Response to Planning Application

Application ref: R/66/20/PL

Description: Residential development consisting of 1No new dwelling. This development is CIL Liable.

Location: Land adjacent to 19 The Bramblings Rustington BN16 2DA

DRAWING TITLE			
Site Plan, Street Elevation Block Plan and Location Plan

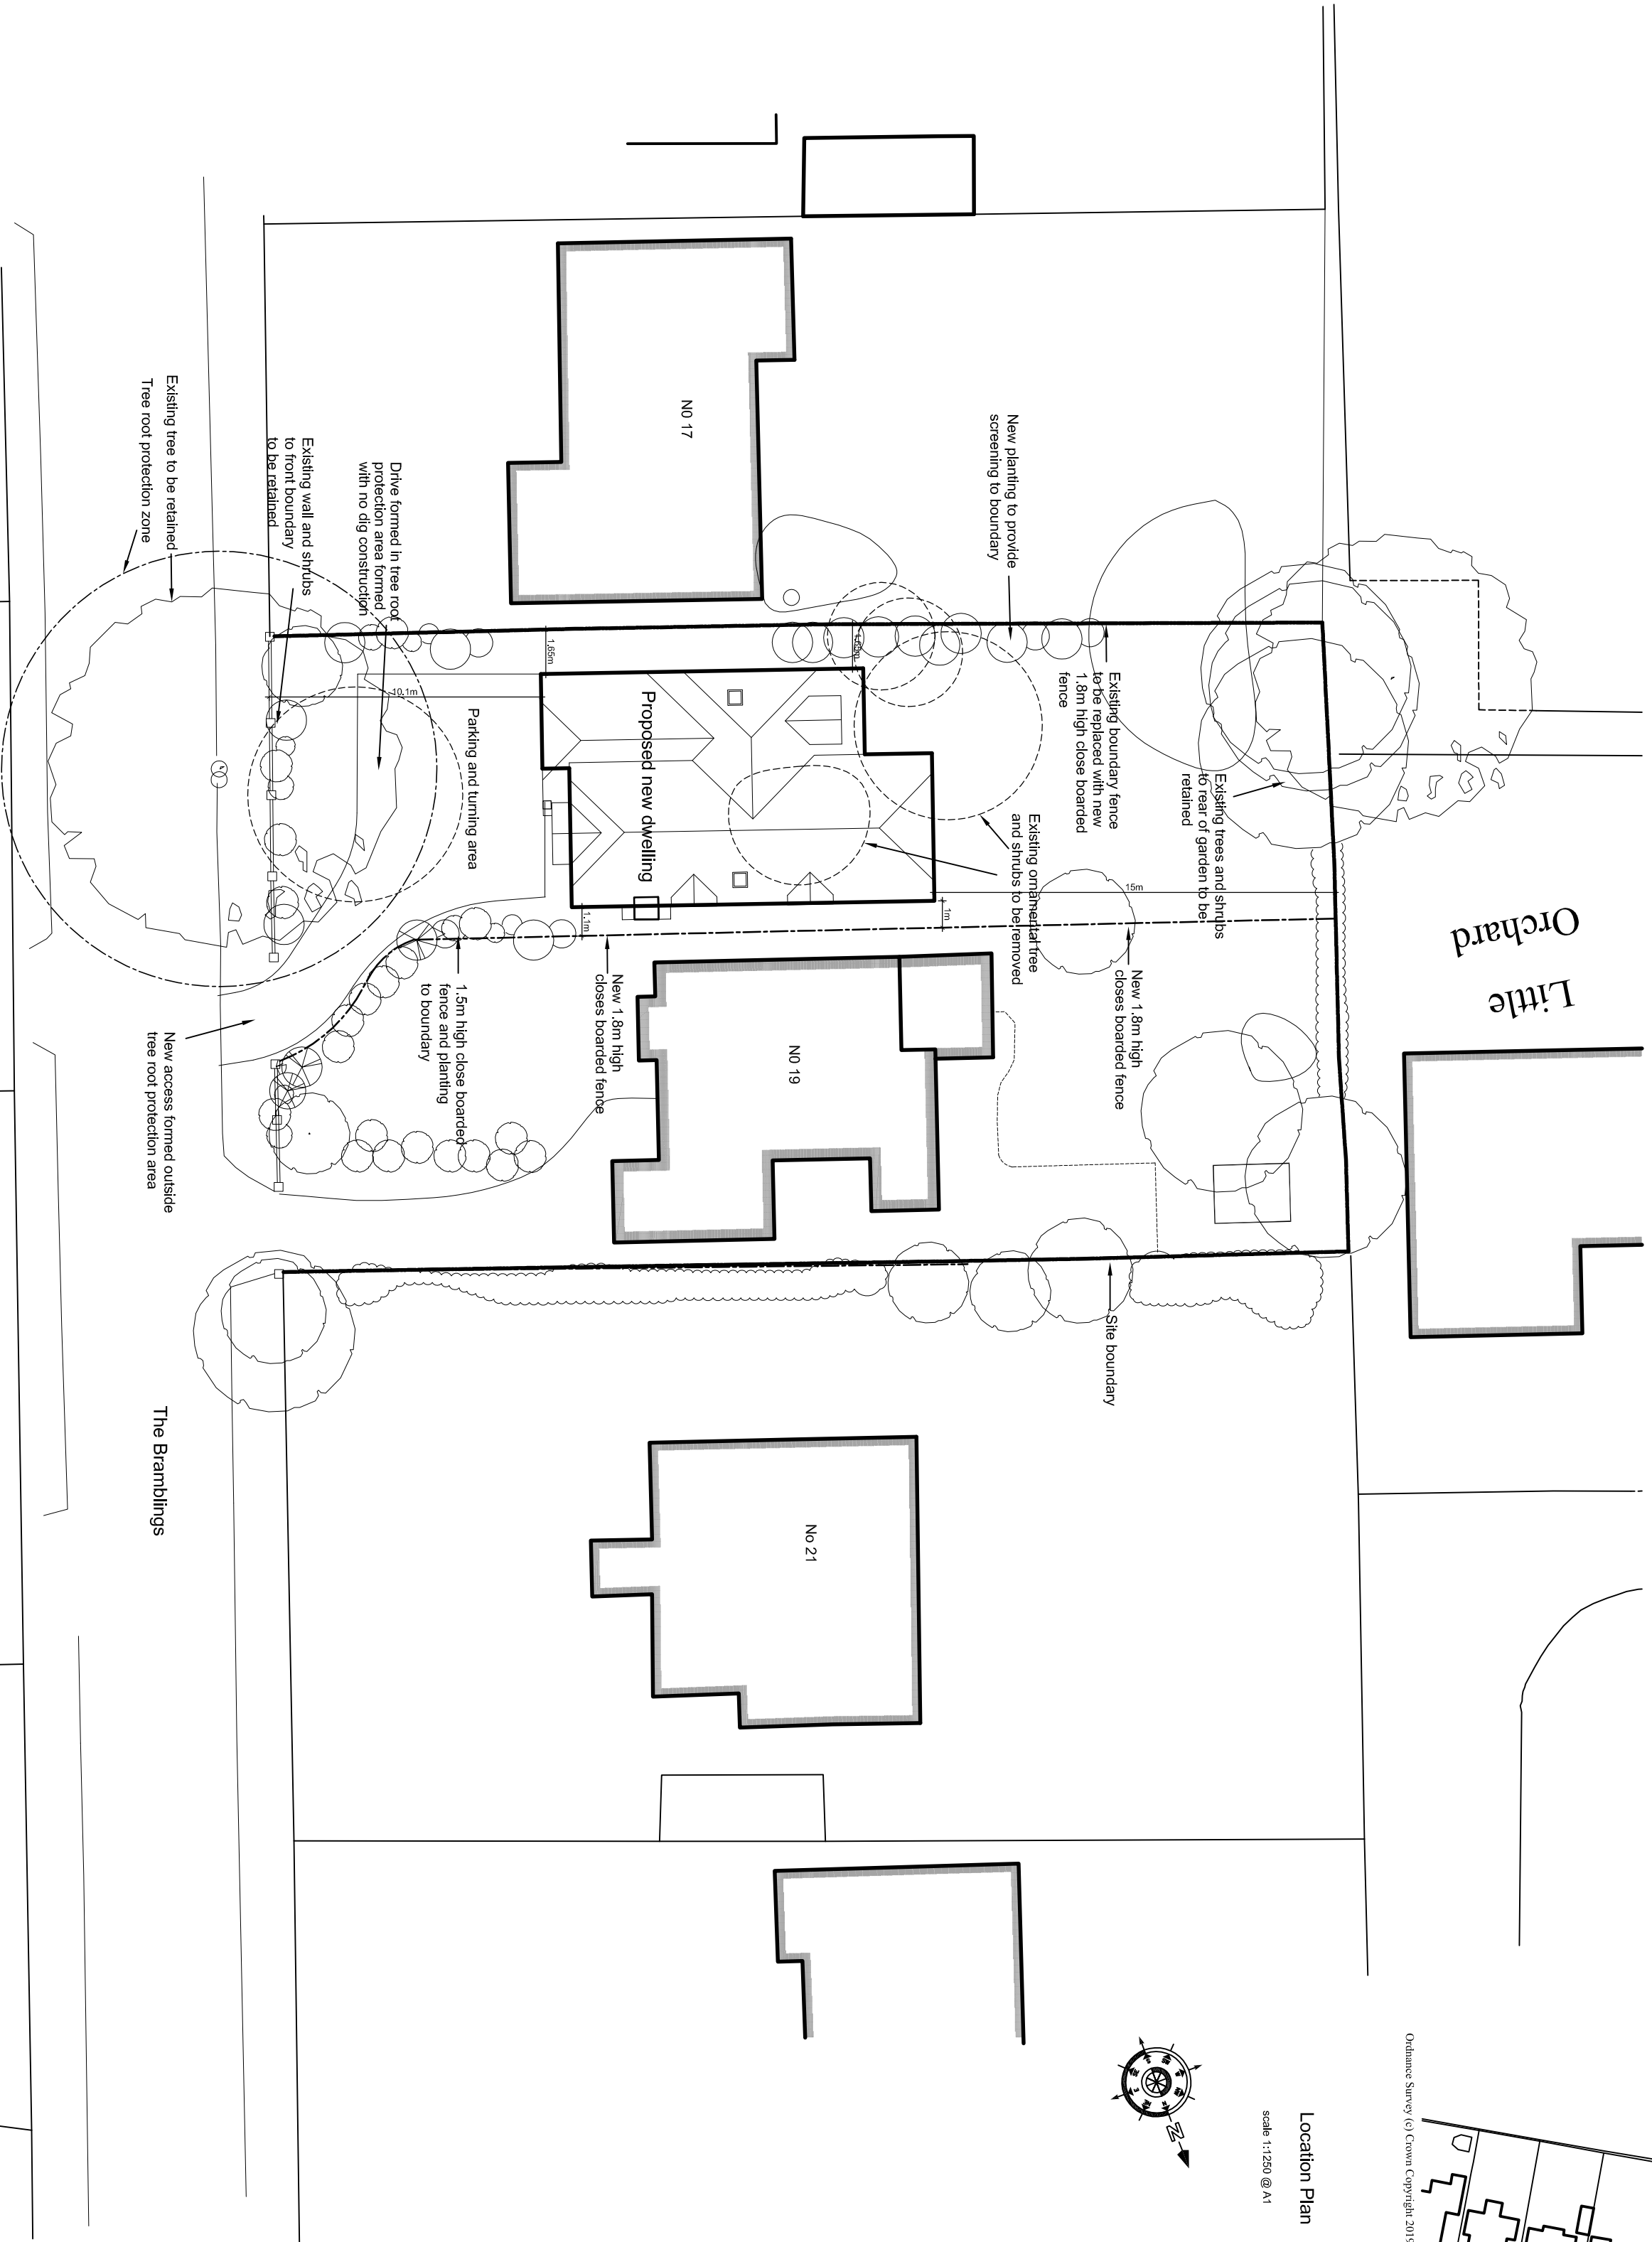
The NPPF para 124/127 relate to good design principles. The indicative location plan has suggested the retention of the majority of the existing trees including the TPO'd Pine and inclusion of new landscaping to this development would be required to be submitted and approved. The inclusion on new landscaping for these proposals should be in consideration of greening and screening and should also consider the biodiversity net gain to be achieved with this development.

No landscape detail has been shown for this development at present. A landscape scheme in plan form would be required to show retained trees and shrubs with proposed plant species detailed along with planting quantities, densities and size at time of planting. All areas should be considered and their connection for biodiversity and habitat explored. All planting specified should be at a suitable size which allow instant impact, but which will establish and mature as the site develops.

I would recommend **no landscape objection** subject to the submission of a detailed landscape scheme to be submitted for approval. Landscape detail to be submitted in plan form to show existing to be retained and new planting detailing species choice, actual quantities, planting densities and size at time of planting.
